# Rezoning Transportation Analysis

Petition Number: 2020-019

General Location Identifier: Tax ID 11101102

Revision Log:	Date	Description
	03-25-20	First Review
	04-20-20	Second Review
	05-20-20	Third Review

**RZ-1**

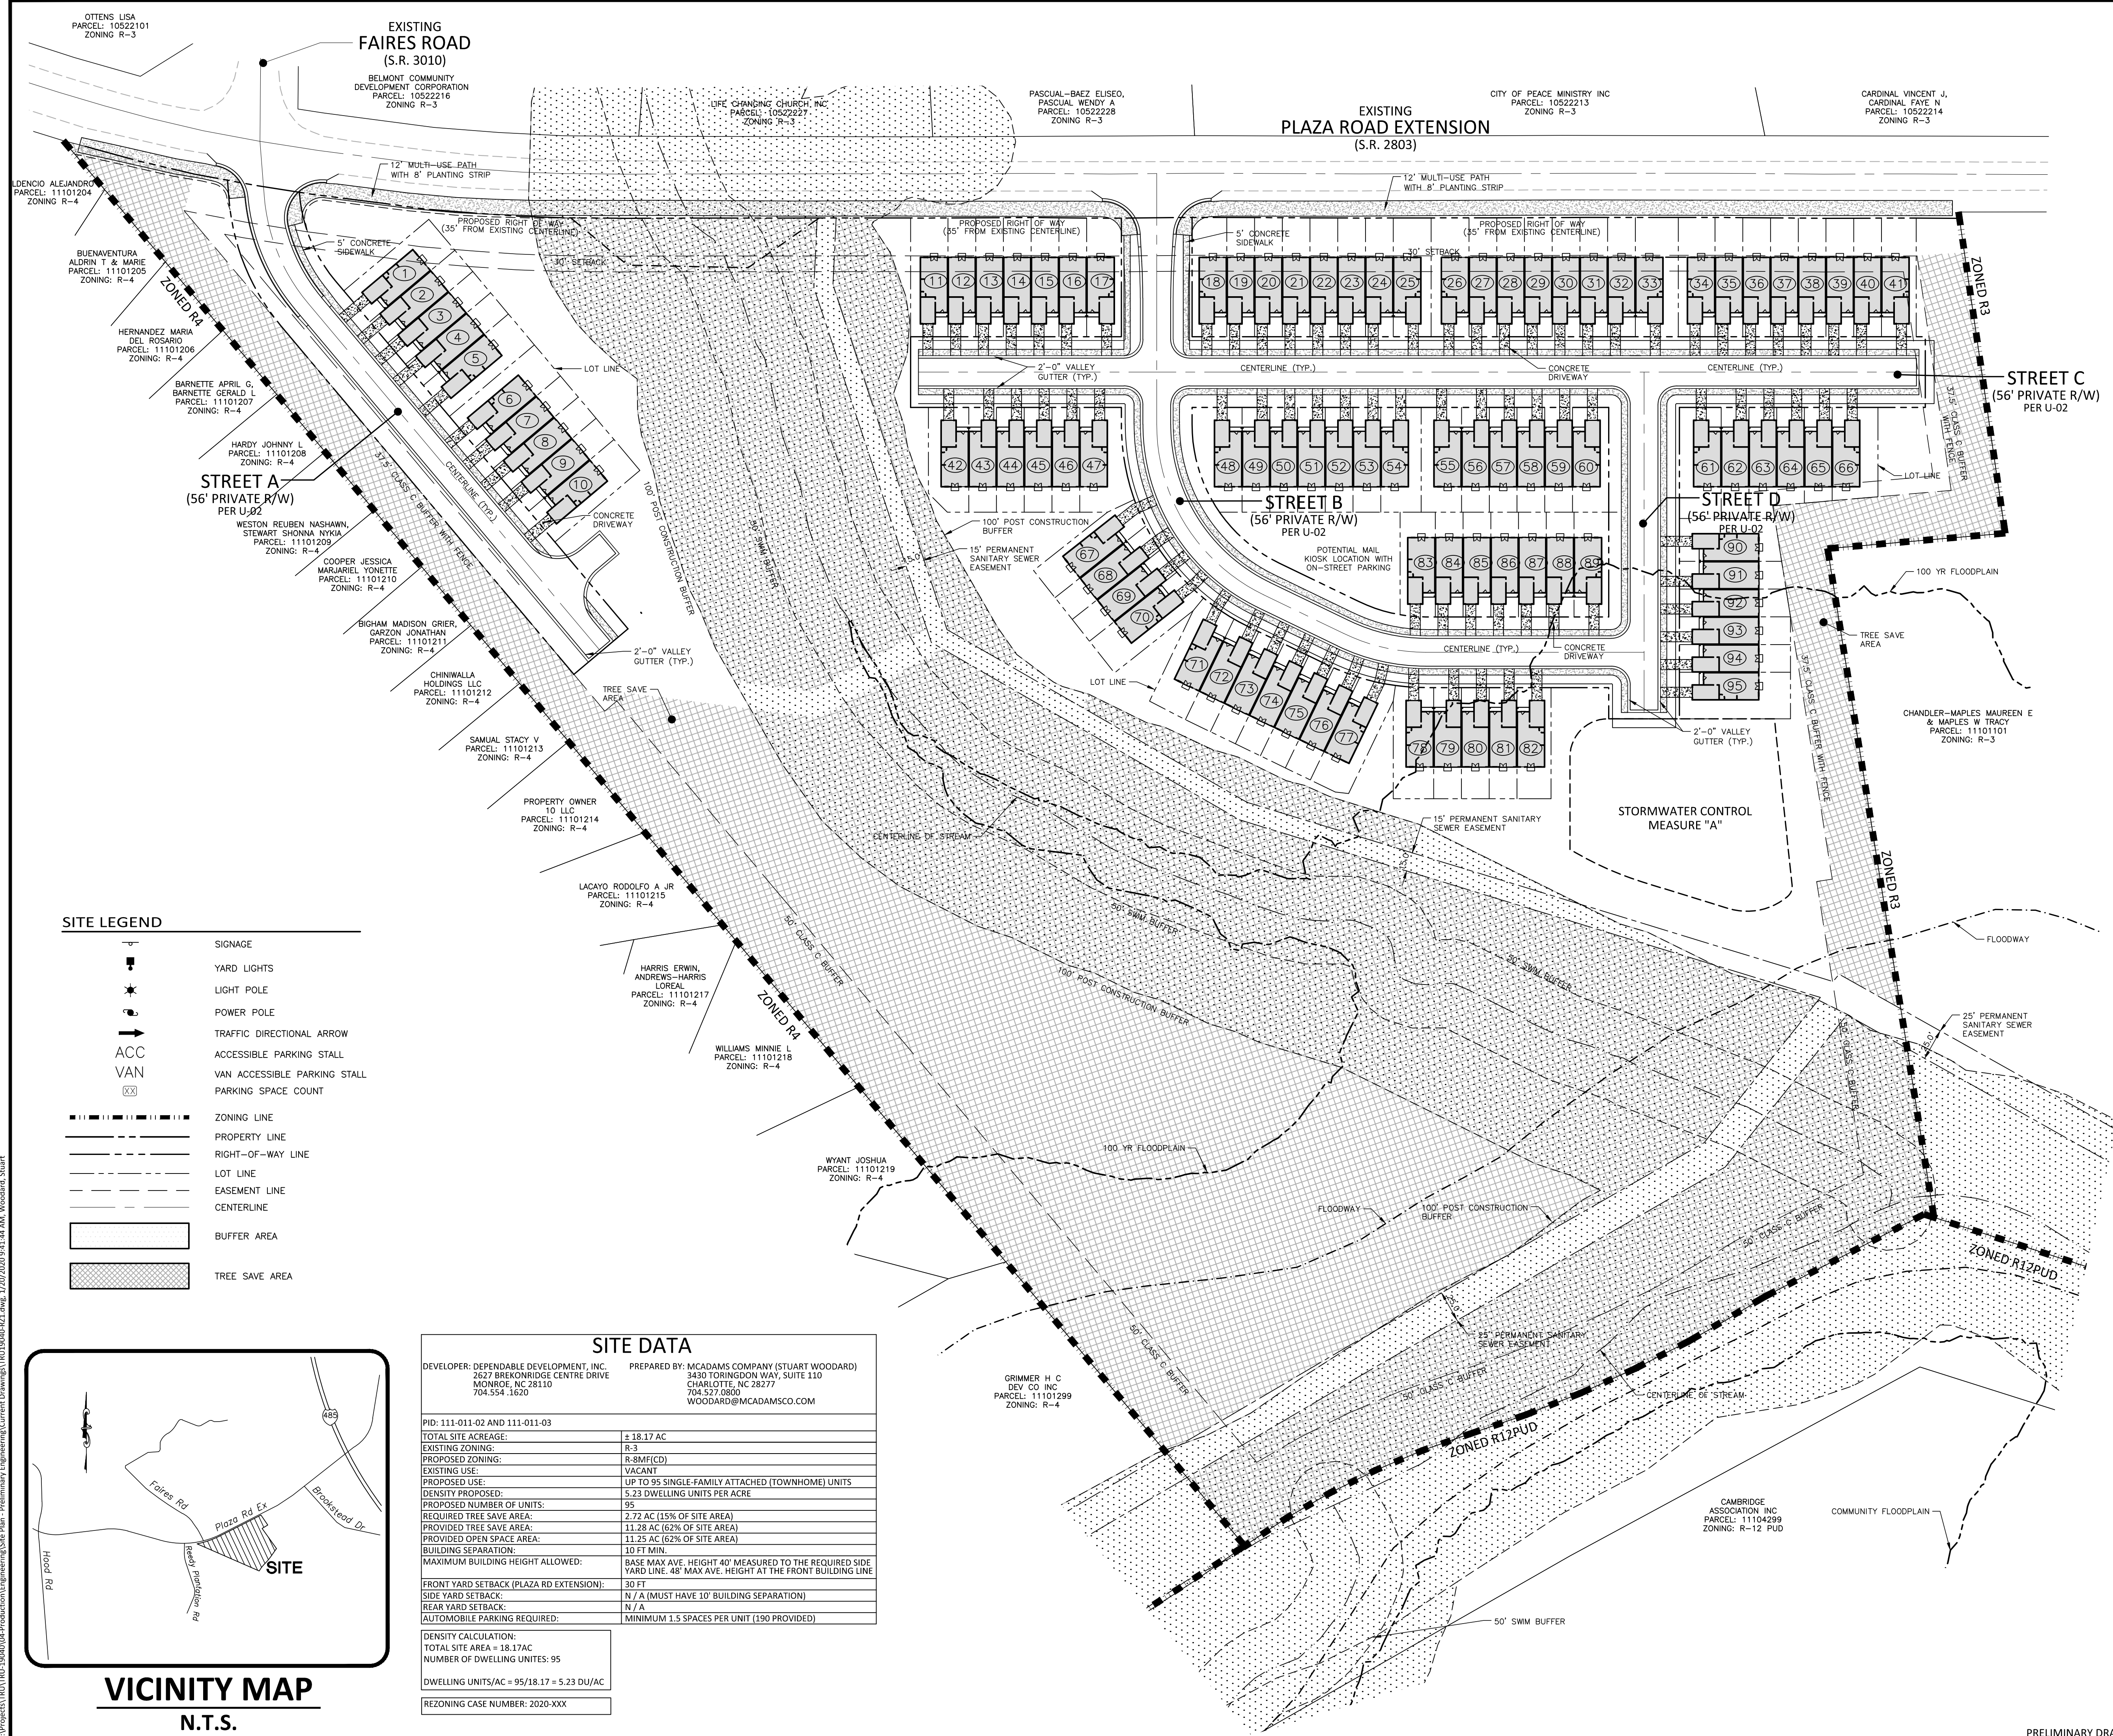
- a. ~~**Plaza Road:** The future back-of-curb is 19' as measured from the street's existing centerline. Chapter 19 of City Code requires curb and gutter along thoroughfares. The petitioner shall revise the site plan and conditional note(s) to commit to construct the curb and gutter. The site plan should label and dimension the future curb and gutter from the centerline of the road. See note 3 for further details.~~

3. ~~The petitioner should revise the site plan and conditional note(s) to commit to dedicate 35' minimum right of way from the Plaza road centerline. The site plan should label and dimension the right of way for all public roads from the road centerline.~~

4. ~~The petitioner should revise the site plan and conditional note(s) to commit to construct a left-turn lane with 150-feet of storage with appropriate tapers based on the posted speed limit for each access point on The Plaza.~~

5. ~~The petitioner should revise the site plan and conditional note(s) to commit to construct a 3-lane section along The Plaza.~~
6. ~~The petitioner should revise the site plan and conditional note(s) to commit to construct an 8-foot planting strip, and 5-foot sidewalk on all the Private Streets. The site plan should label and dimension both items~~

7. ~~The petitioner should revise the site plan and conditional note(s) to commit to construct an 8-foot planting strip, and 6-foot sidewalk on Street C. The site plan should label and dimension both items.~~
